Application Ref:	3/2026/0382			 Ribble Valley Borough Council www.ribblevalley.gov.uk
Date Inspected:	26/06/26	Site Notice:	26/06/26	
Officer:	LW			
DELEGATED ITEM FILE REPORT:				REFUSAL

Development Description:	Proposed second floor extension to rear to provide additional Class E space, alterations and creation of new window and door openings.
Site Address/Location:	10 King Street, Clitheroe, BB7 2EU.

▼ 80.00m above OS Datum
South East Elevation

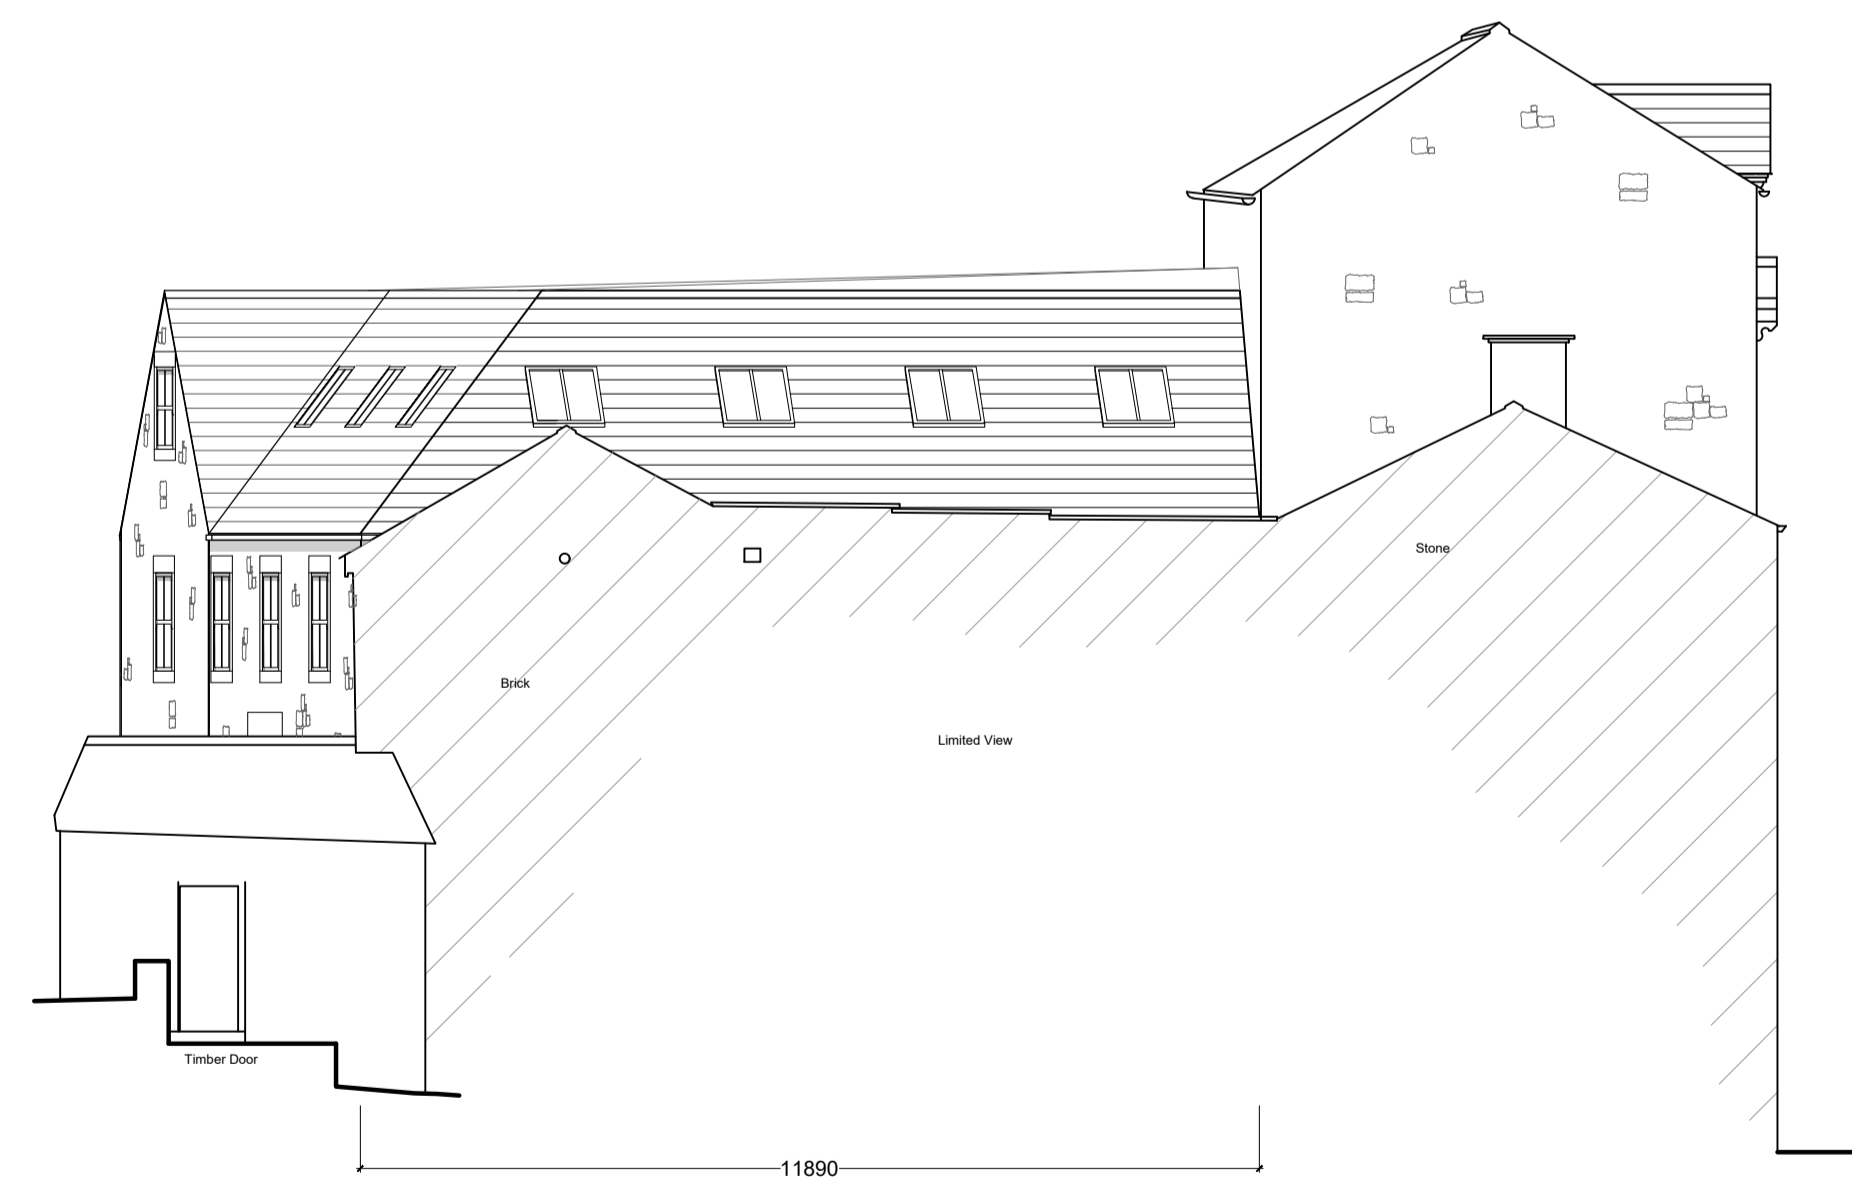
feature would be introduced on the south-eastern elevation, with a new full-height window positioned beneath. Existing first-floor window openings on this elevation would also be raised.

The proposed extension would substantially alter the appearance of the existing structure. The increased ridge height, steeper roof profile and the introduction of numerous new window openings and rooflights would significantly change the character of the building. In particular, the quantity of window openings and rooflights and enlarged roof form, would introduce a more domestic appearance that would be at odds with the simple, utilitarian character currently exhibited by the building.

As a result, the proposal would erode the historic and functional qualities that contribute to the significance of the existing structure and would appear anomalous and incongruous when viewed alongside the other traditional backplot buildings that characterise this part of the Conservation Area. The development would therefore fail to preserve the character and appearance of this part of the Conservation Area and would result in a degree of harm to its significance.

RECOMMENDATION:	That planning consent be refused for the following reason:
01:	The proposed extension, by reason of its increased ridge height, steeper roof form and the introduction of numerous additional window openings and rooflights, would materially alter the character and appearance of the existing building. The cumulative effect of these alterations would introduce of a more domestic form that would be incongruous with, and detrimental to, the building's simple and utilitarian character. As a result, the proposal would fail to preserve or enhance the character and appearance of the Clitheroe Conservation Area, causing less than substantial harm to its significance which is not outweighed by any public benefit arising from the development. The proposal therefore conflicts with Key Statement EN5 and Policies DME4 and DMG1 of the Ribble Valley Core Strategy, Section 72 of the Planning (Listed Buildings and

Third Floor and Roof Plan  
1:100 Scale

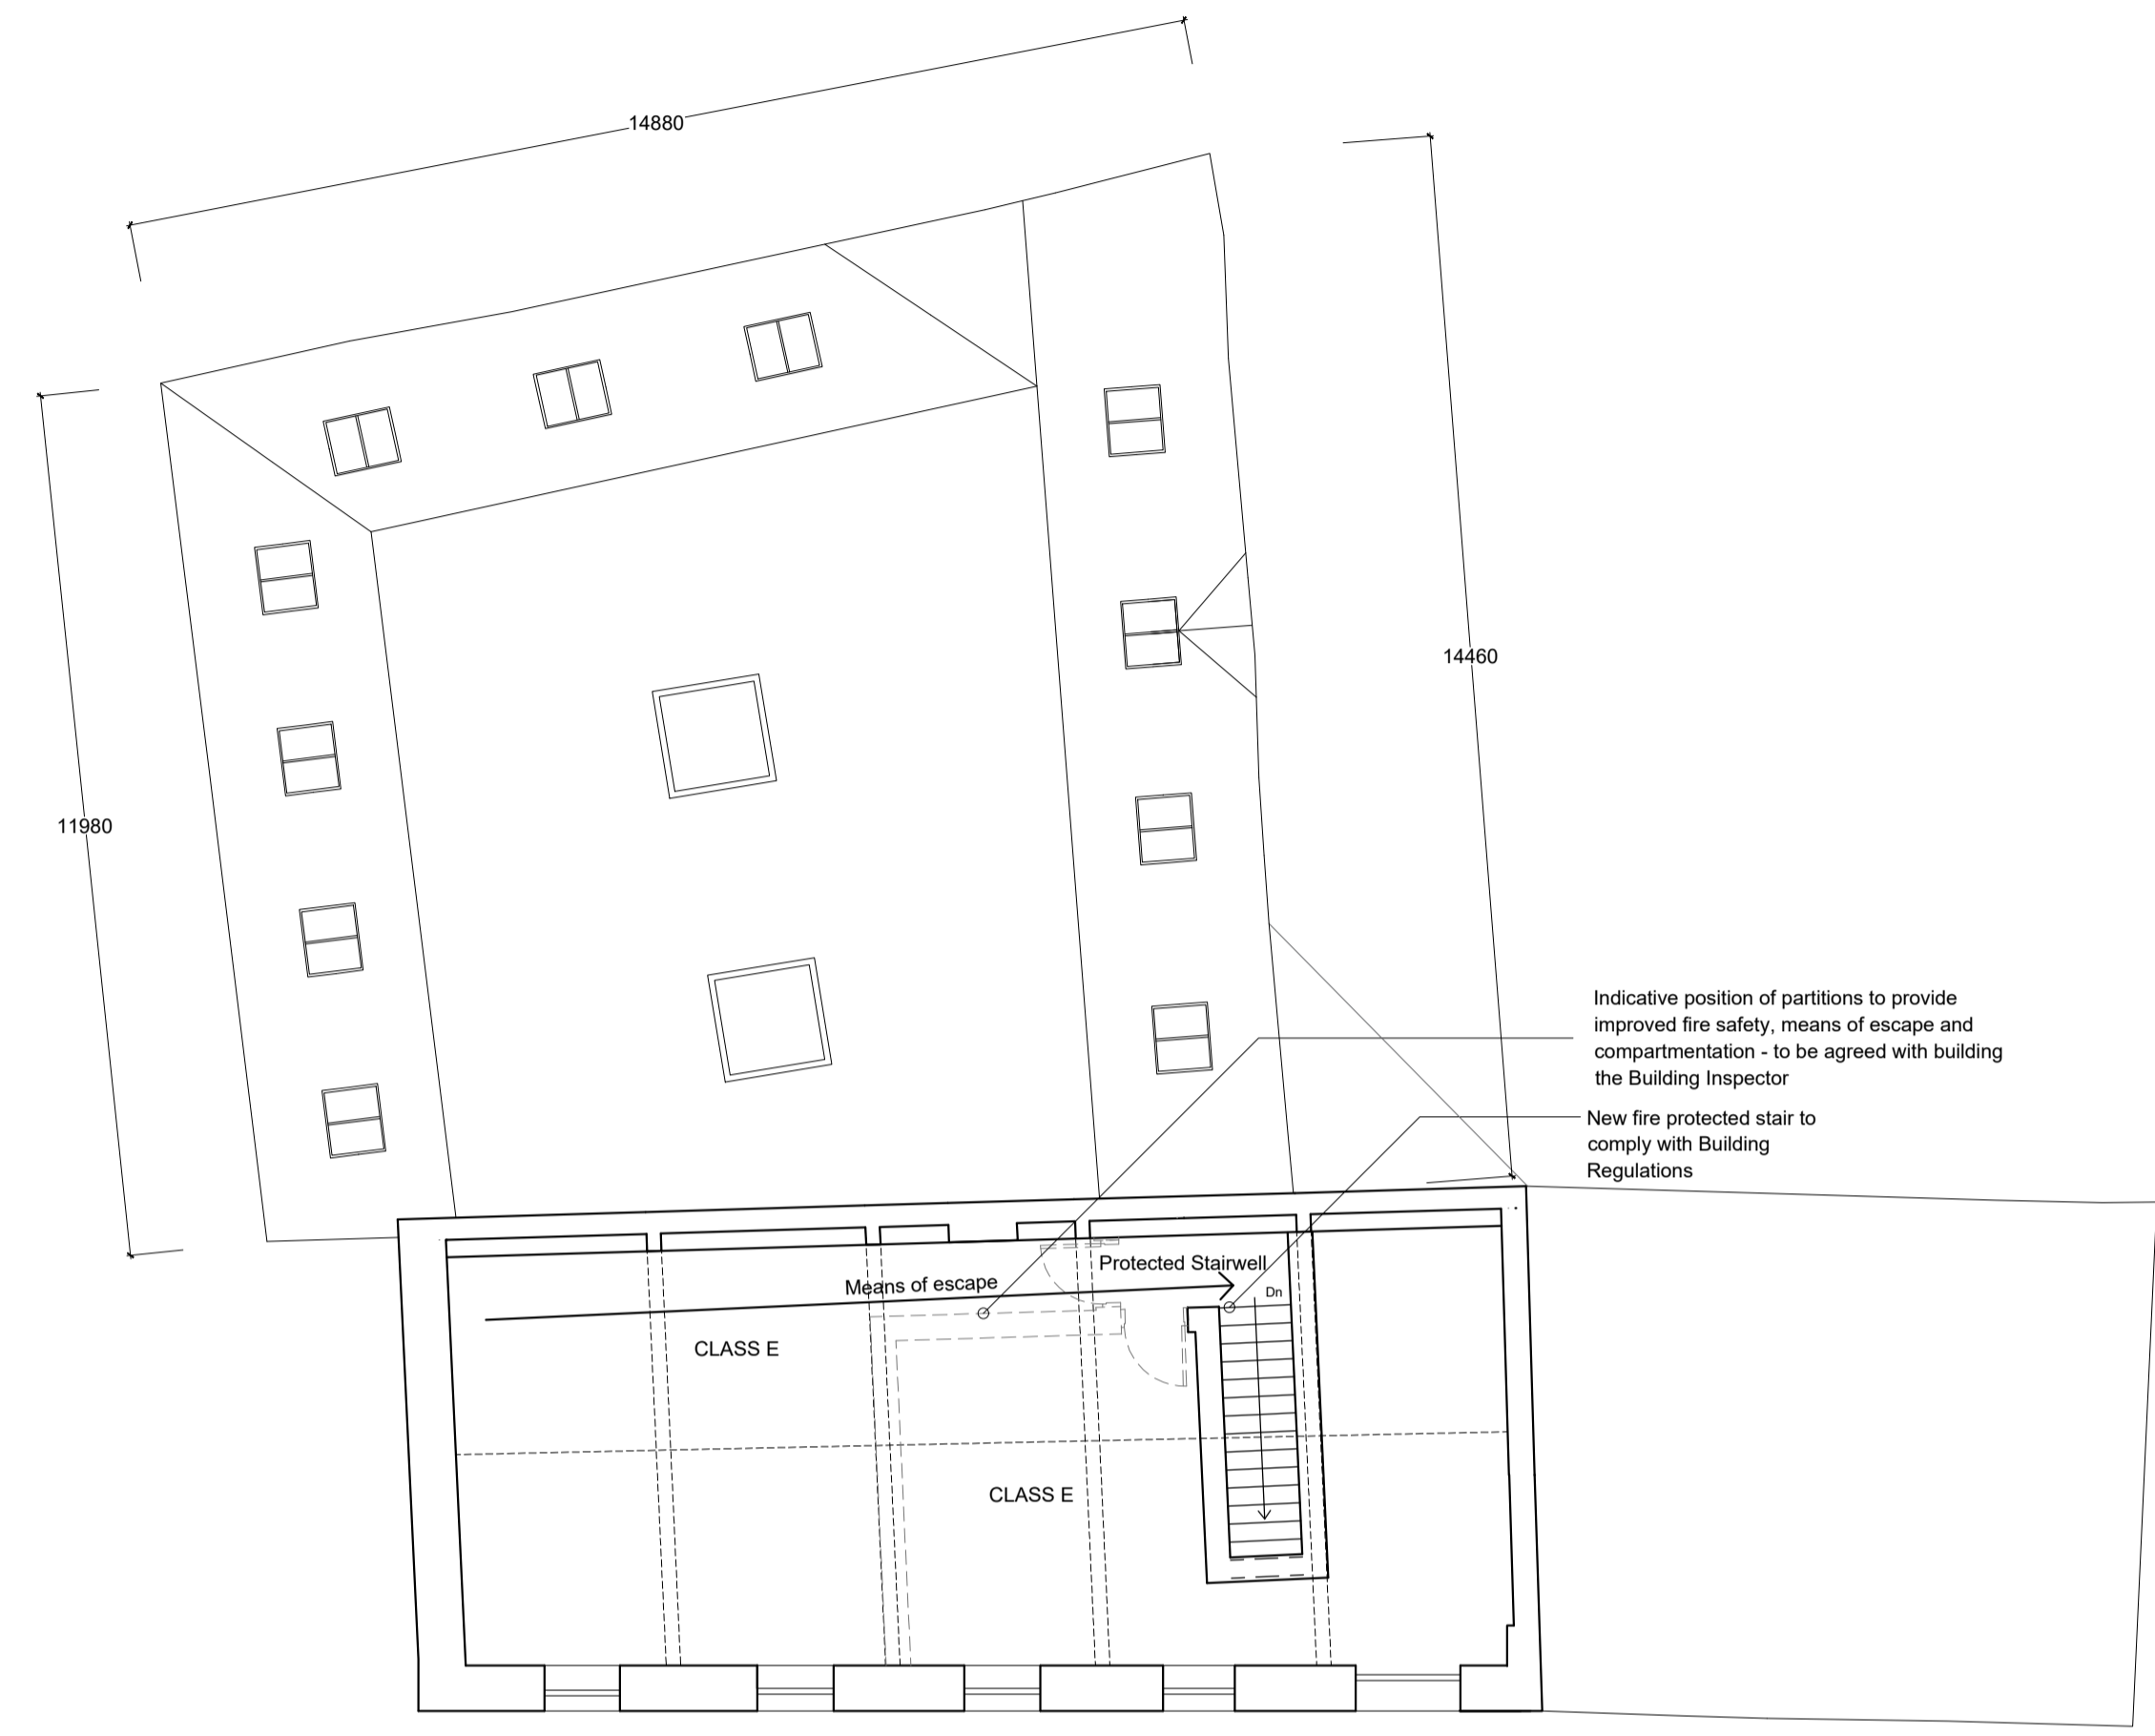
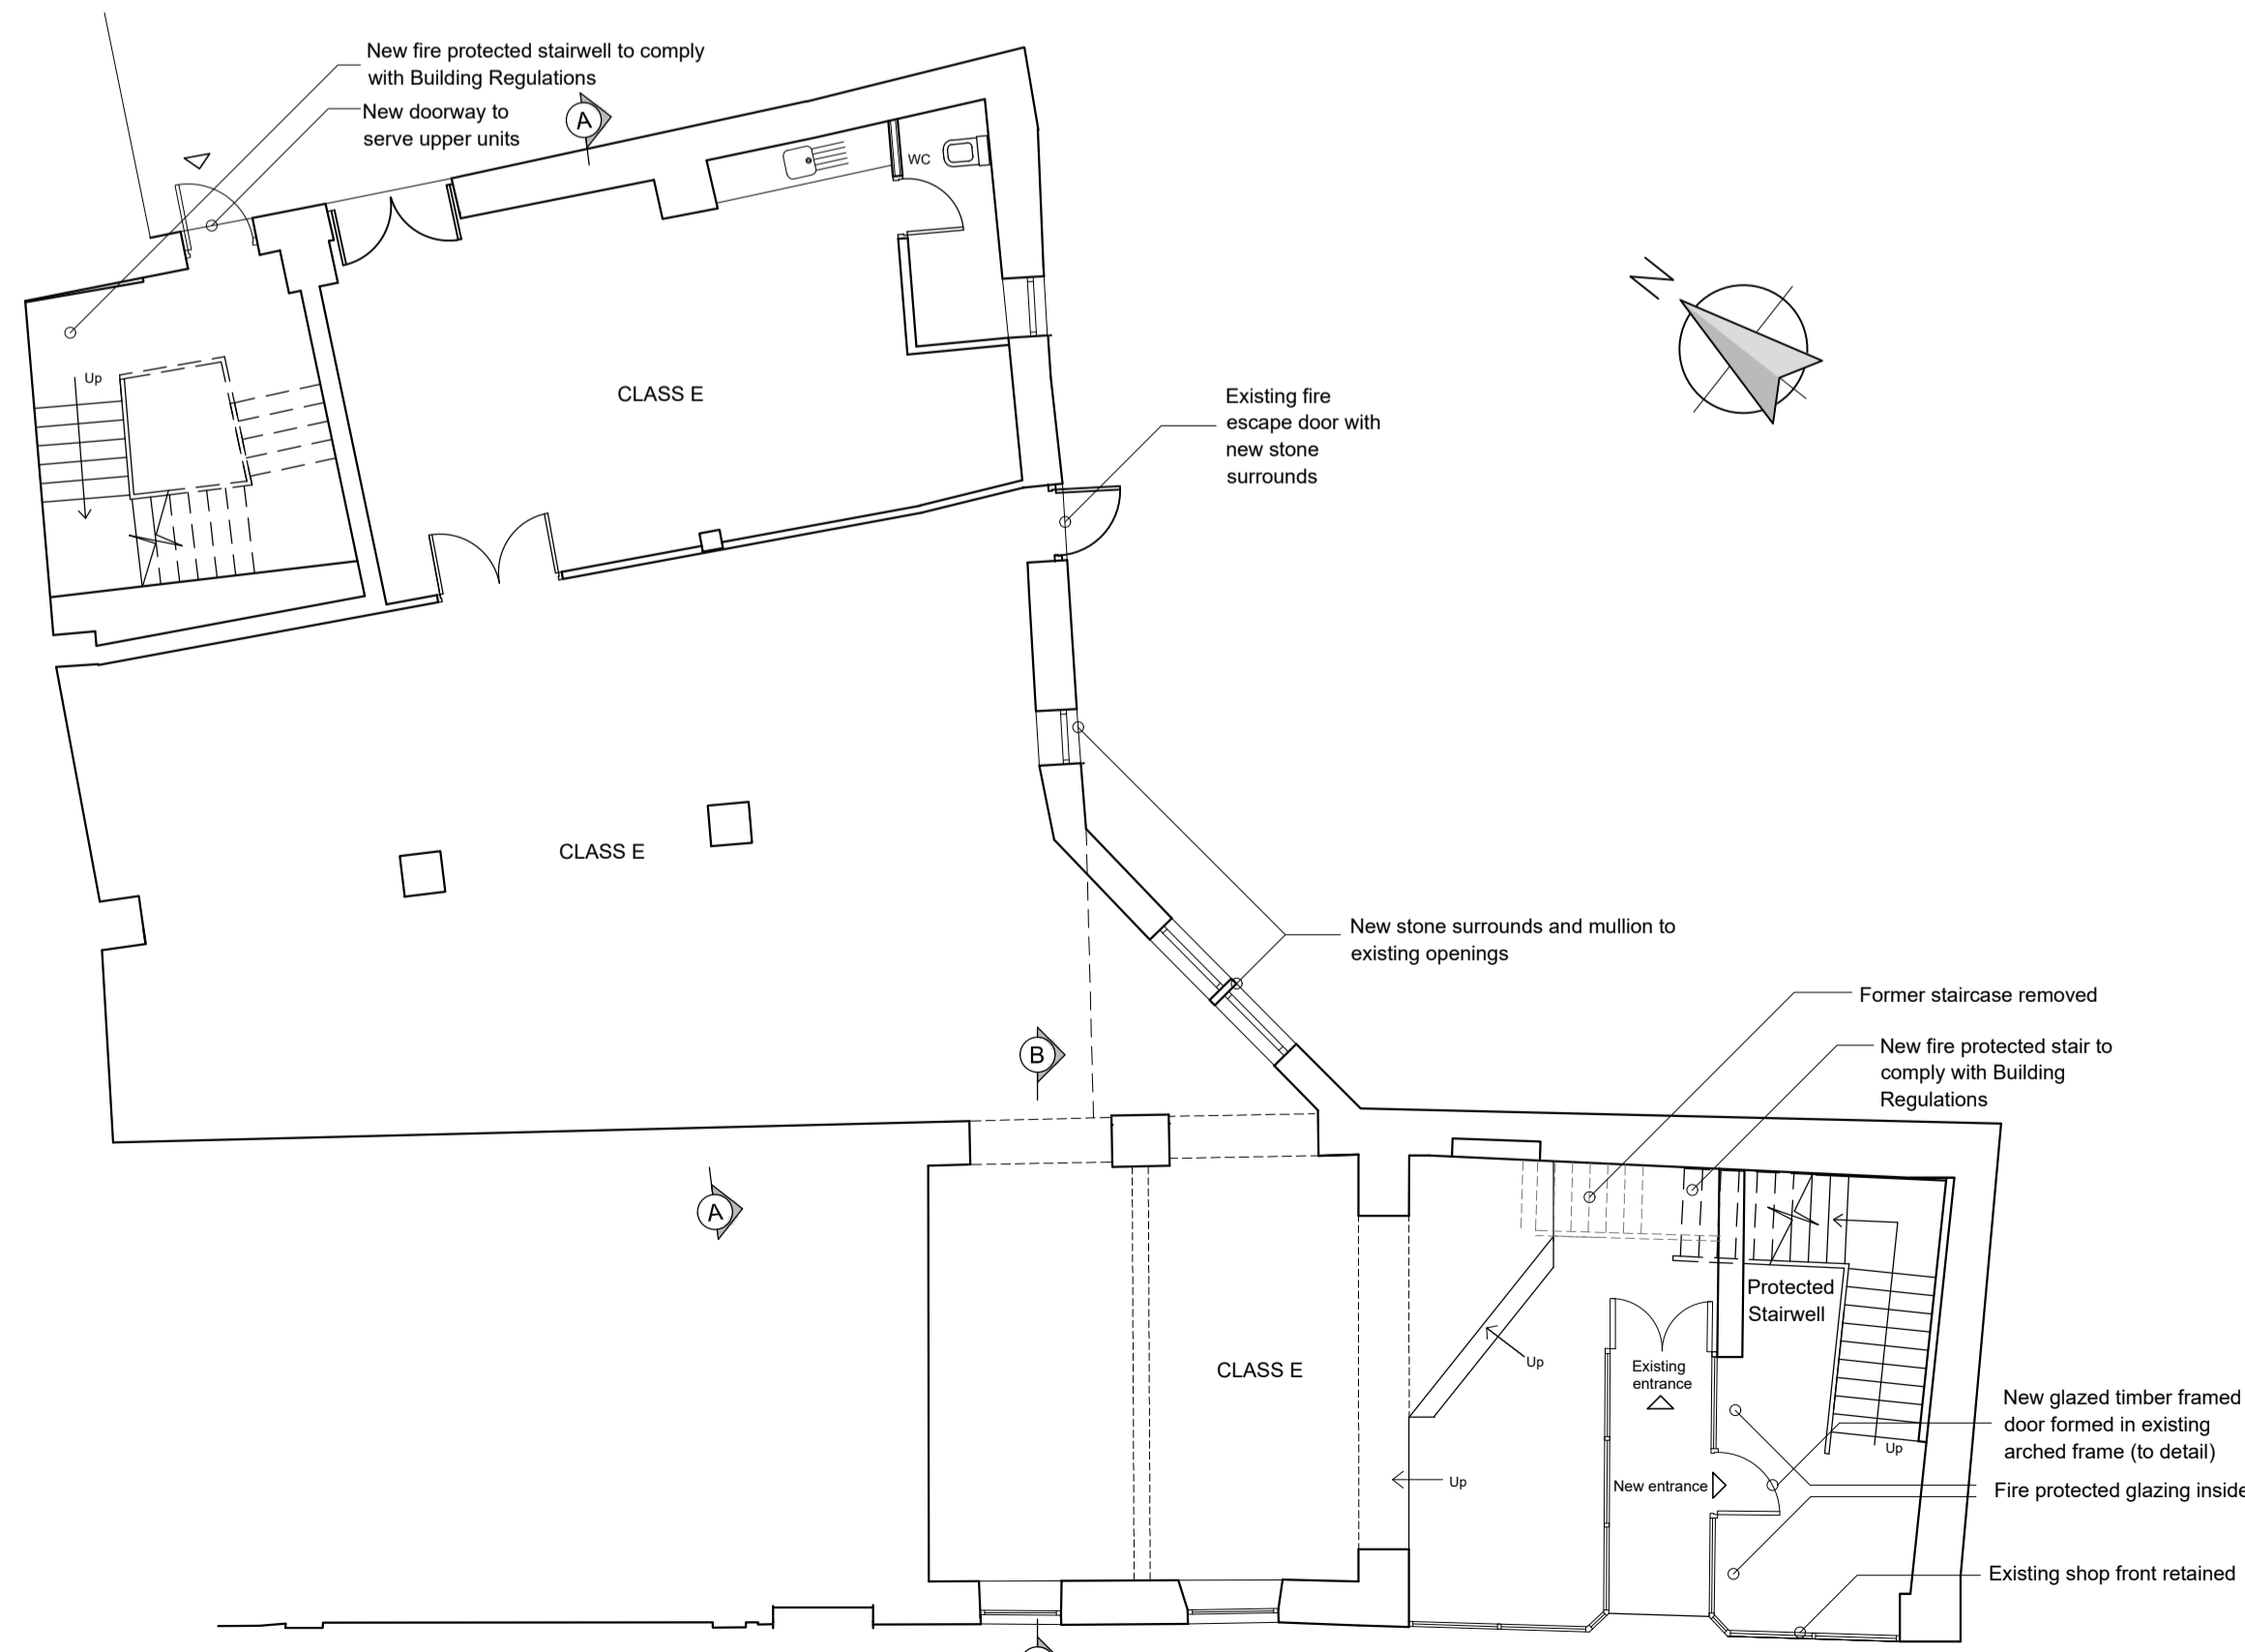
The proposed additional accommodation would be largely created within the roof space of the existing rear projection. The development would involve an increase in the overall ridge height of approximately 2 metres and an increase in the eaves height of approximately 0.4 metres. The extension would incorporate a total of 13 conservation-style rooflights, comprising 11 rooflights within the pitched roof slopes and a further two rooflights within the flat roof section. A gabled
